From: BCTAdmin@thameswater.co.uk
To: [Planning](#)
Subject: 3rd Party Planning Application - 6/2019/3024/MAJ
Date: 30 December 2019 11:06:14

Our DTS Ref: 61345
Your Ref: 6/2019/3024/MAJ

Re: 29, BROADWATER ROAD, WELWYN GARDEN CITY, HERTFORDSHIRE , AL7 3BQ

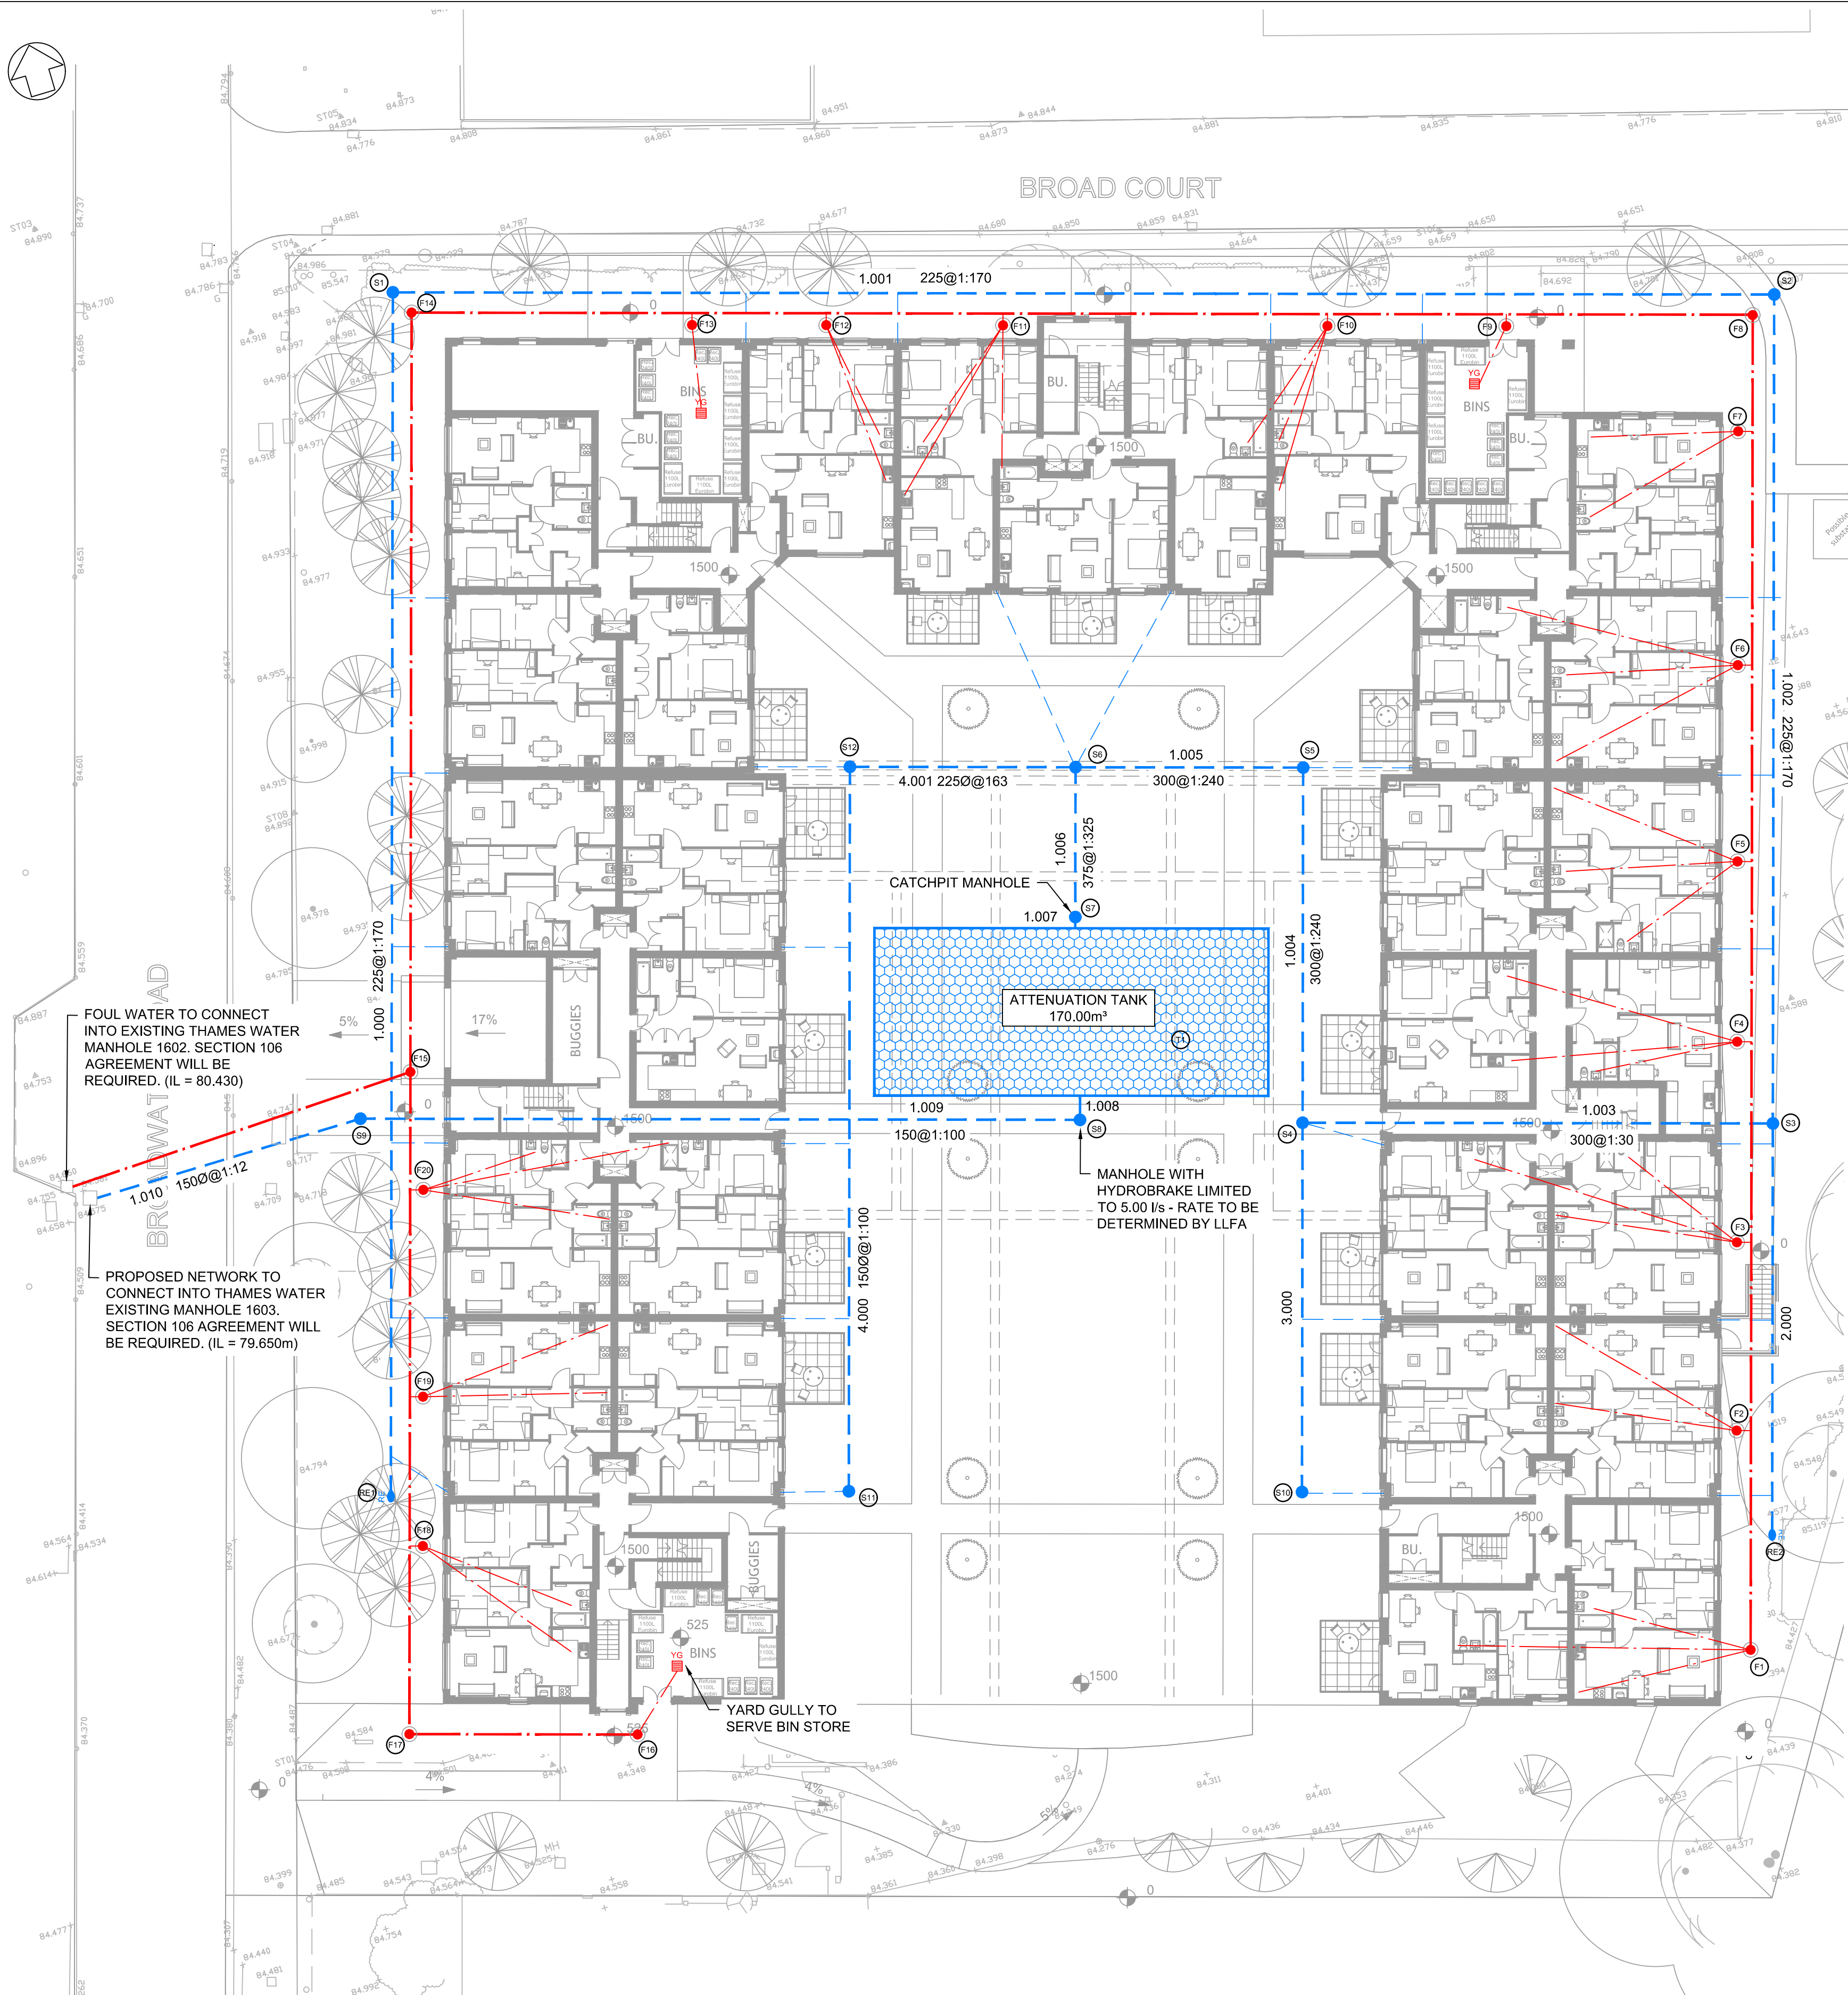
ST 30/12/2019: It is mentioned in your drainage strategy document that you are planning to discharge foul water in Thames Water existing manhole 1602. According to our records, this manhole serves the surface network and not foul. The closest manhole to MH1602 that serves foul network is MH1601. With regard to foul

water and based on the above, we would not have any objection to use MH1601 as connection point for foul.
